From: Bloomer, David <David.Bloomer@lancashire.gov.uk>
Sent: 31 August 2018 14:02
To: John Macholc
Cc: LHS Customer Service; planning
Subject: app3/2018/0529 The Moorcock Slaidburn

I have a couple of issues with the submitted Construction Management Plan, whilst most of the information is generic in terms of expectations of how the site will be operated the , my comments are based on the 2 site plans submitted.

Site Plan

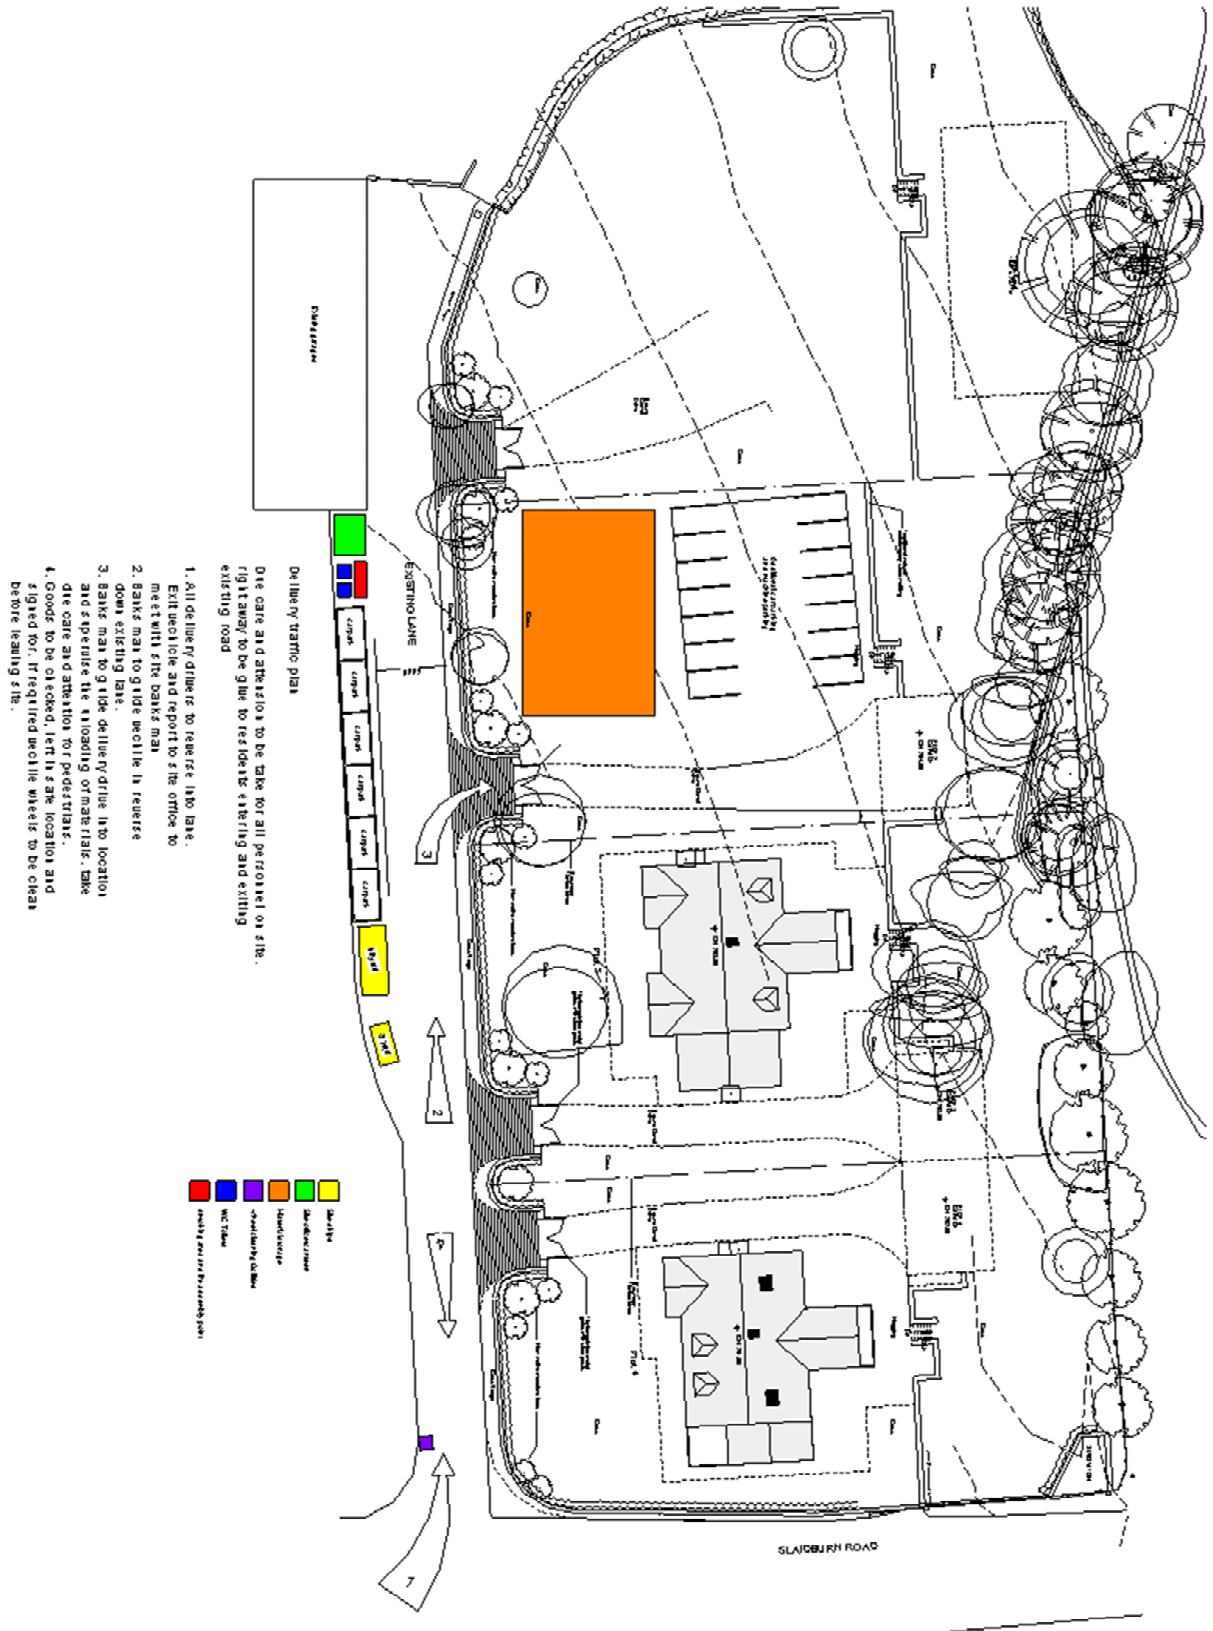
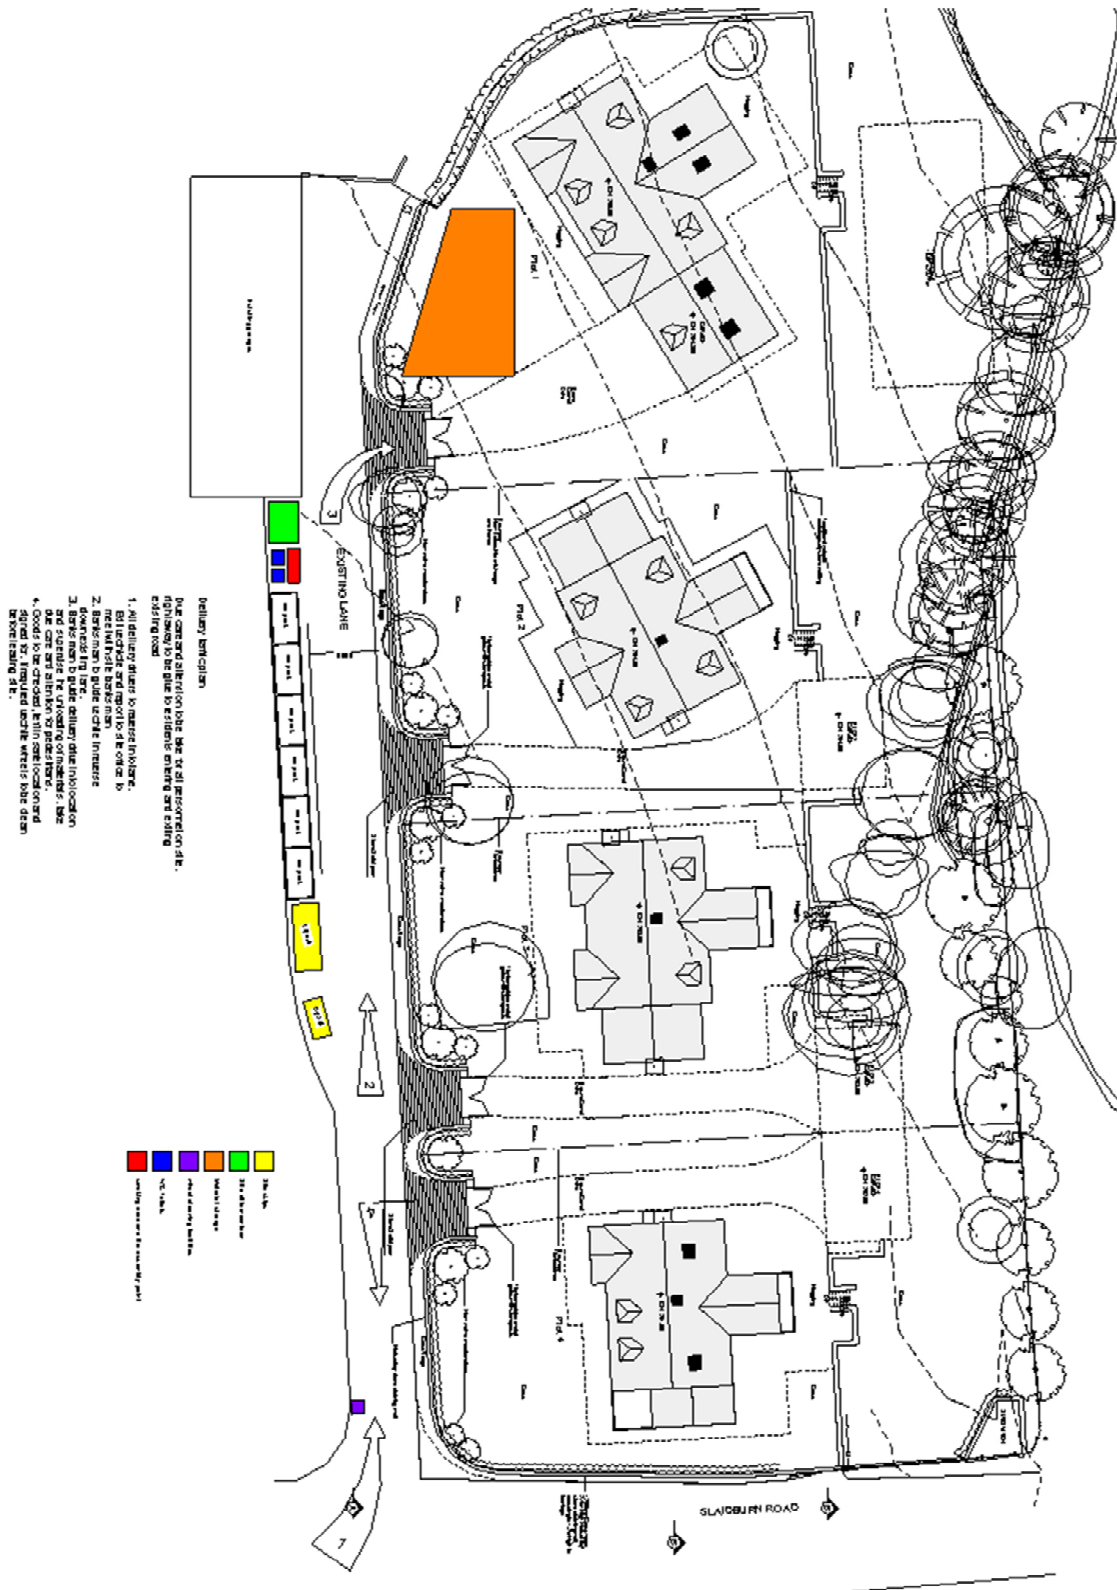
1 The wheel wash area I located too close to the junction with Slaidburn Road and will impede the movement of vehicles to and from Slaidburn Road which would not be acceptable also the is a greater likelihood of washings flowing or being onto the highway. The facility should be located further along the access road towards the skip area.

2 Phase 1 provides 20 parking spaces , 6 along the access road and 14 adjacent to the storage compound for the construction of 2 units , however in phase 2 whilst the parking demand would be similar for the construction of the remaining 2 units only 6 parking spaces are provided. Further clarification is required.
